# ENG-SF21020-R2-Plat.pdf Markup Summary

# FALCON MEADOWS AT BENT GRASS FILING NO. 1

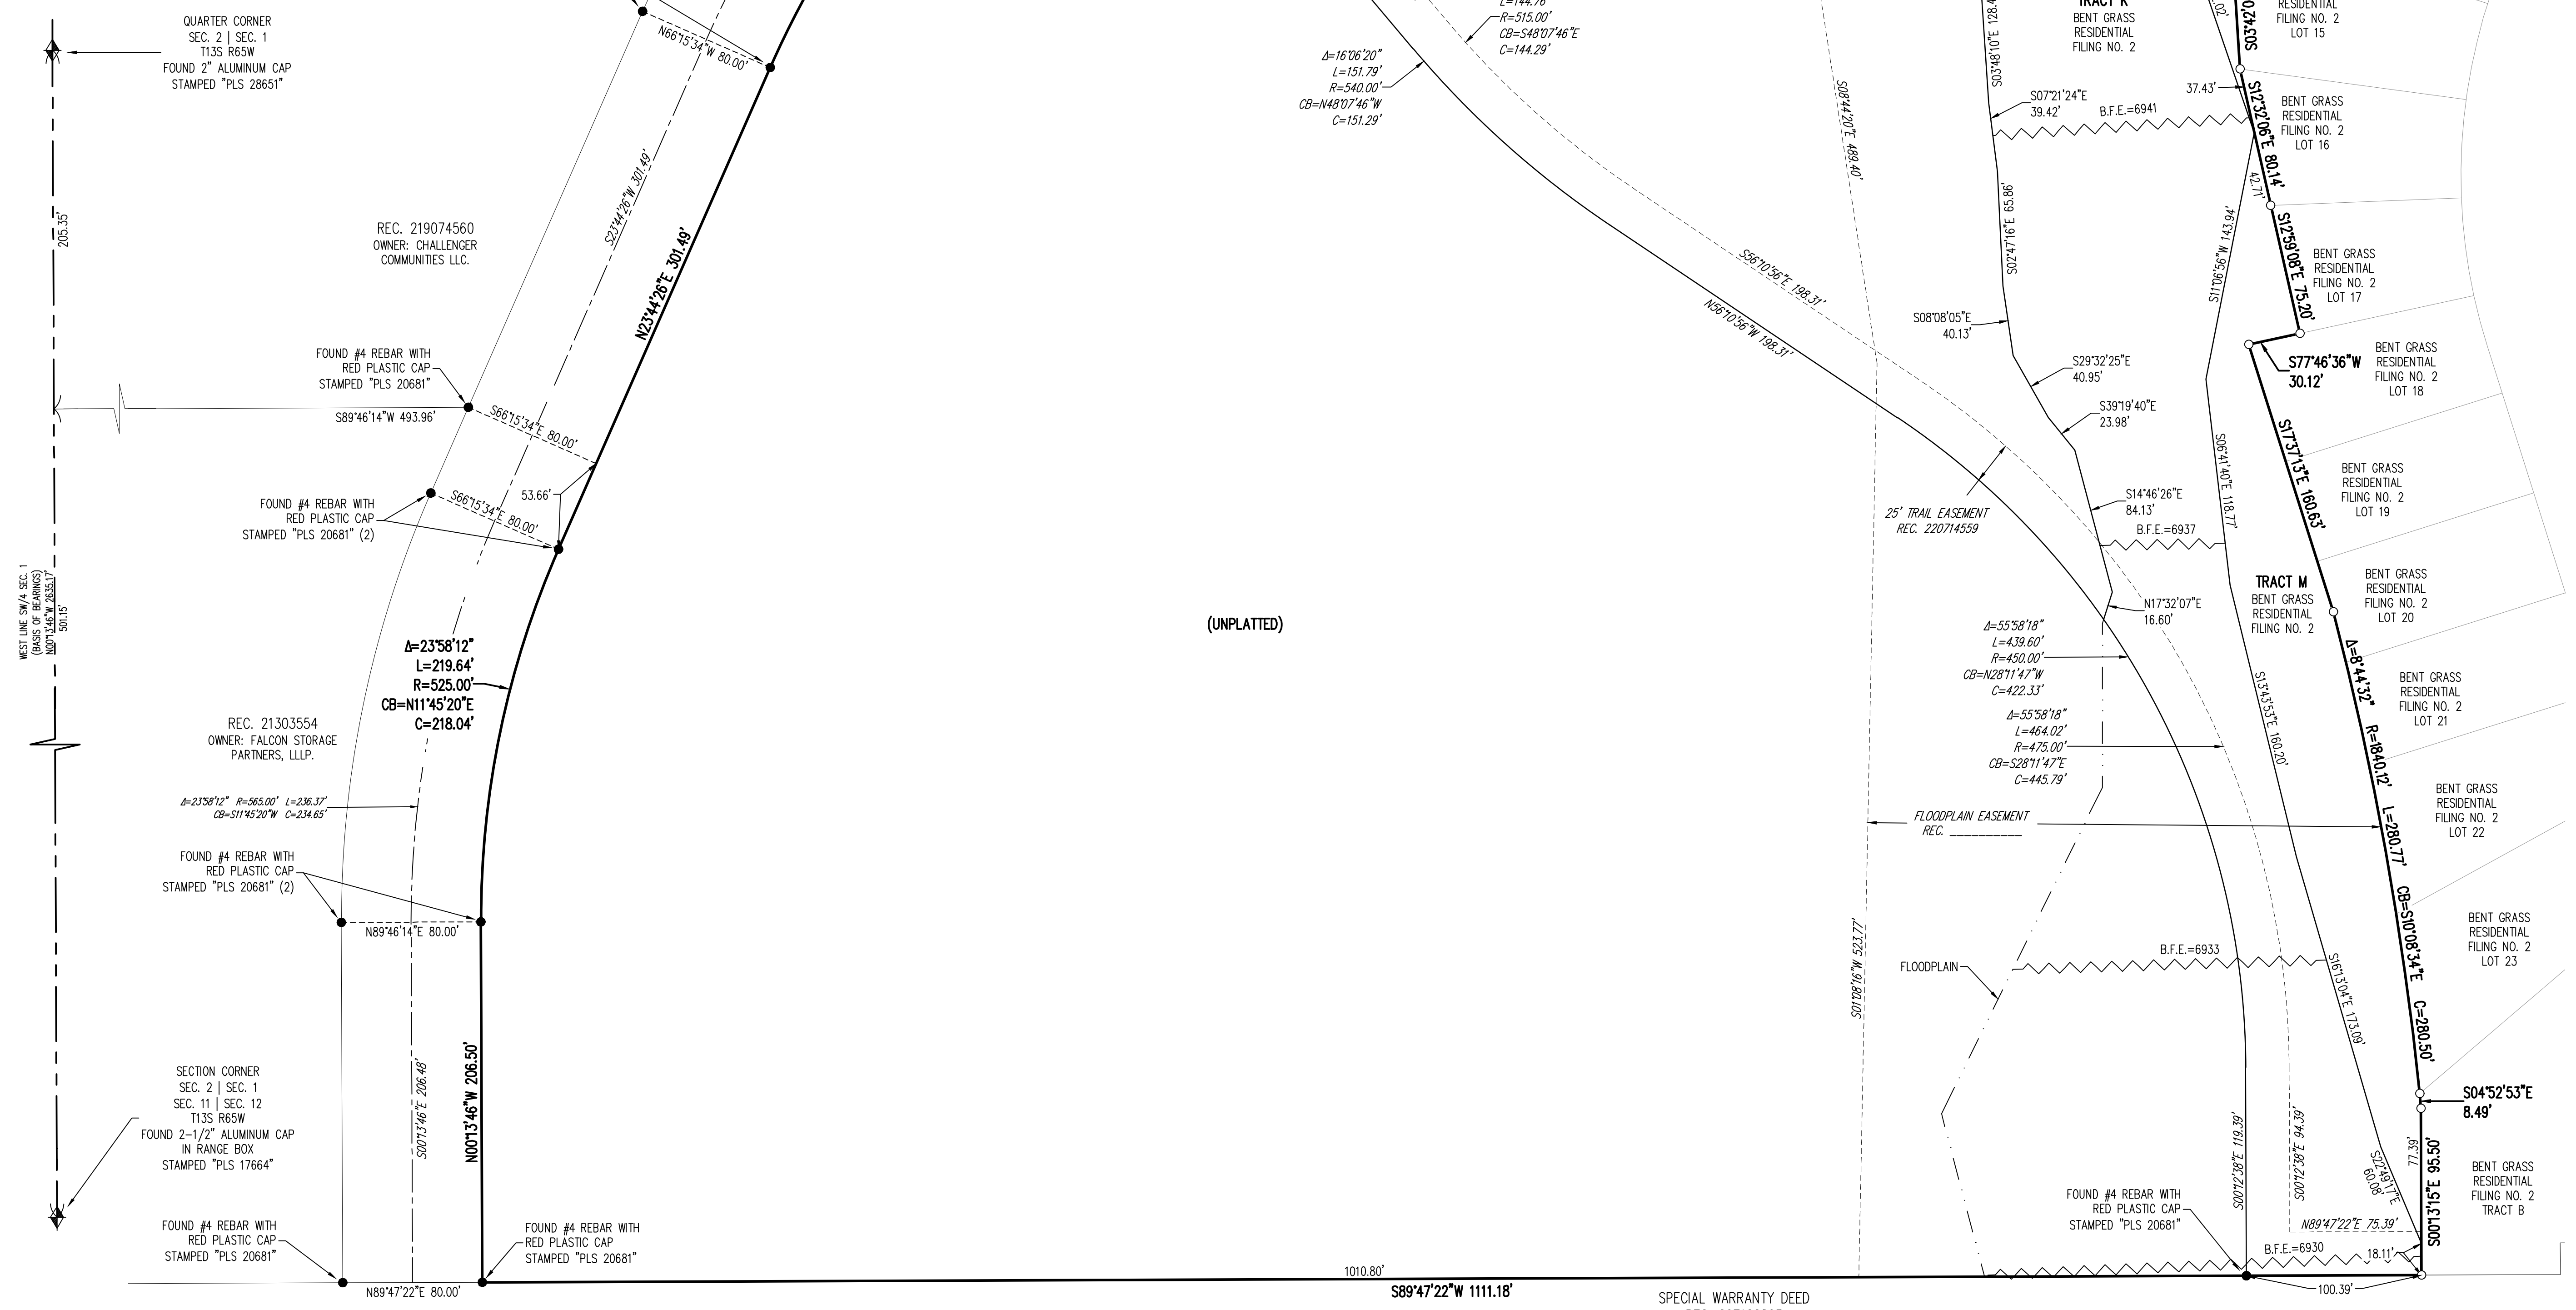
wrong name

Drainage basin and fee\_\_\_\_\_

must be on first page

is that correct

non- basements as mitigation to groundwater - add note (see report)

Drainage basin and fee\_\_\_\_\_

duplicate from first page

not correct

Add the note: This plat has been plat checked by PPRBD, the stamped approval is recorded at Reception No. \_\_\_\_\_

i dont think we are taking this until improvements are done....

not correct

Please state that tis in within a PUD, Name that PUD and cite the reception number of the PUD.

Bent Grass Metro District until accepted by EPC

trail?

Note Regarding Stormwater Drainage:  
All property owners are responsible for maintaining proper storm water drainage in and through their property. Public drainage easements as specifically noted on the plat shall be maintained by the individual lot owners unless otherwise indicated. Structures, fences, materials or landscaping that could impede the flow of runoff shall not be placed in drainage easements.

This property is subject to a Private Detention Basin/Stormwater Quality BMP Maintenance Agreement and Easement as recorded at Reception No. \_\_\_\_\_ of the records of El Paso County. The Bent Grass Metropolitan District is responsible for maintenance of the subject drainage facilities

Bent Grass Metropolitan District shall be responsible for maintenance of the drainage channel in Tract E until the necessary channel stabilization improvements have been constructed and accepted for maintenance by El Paso County.
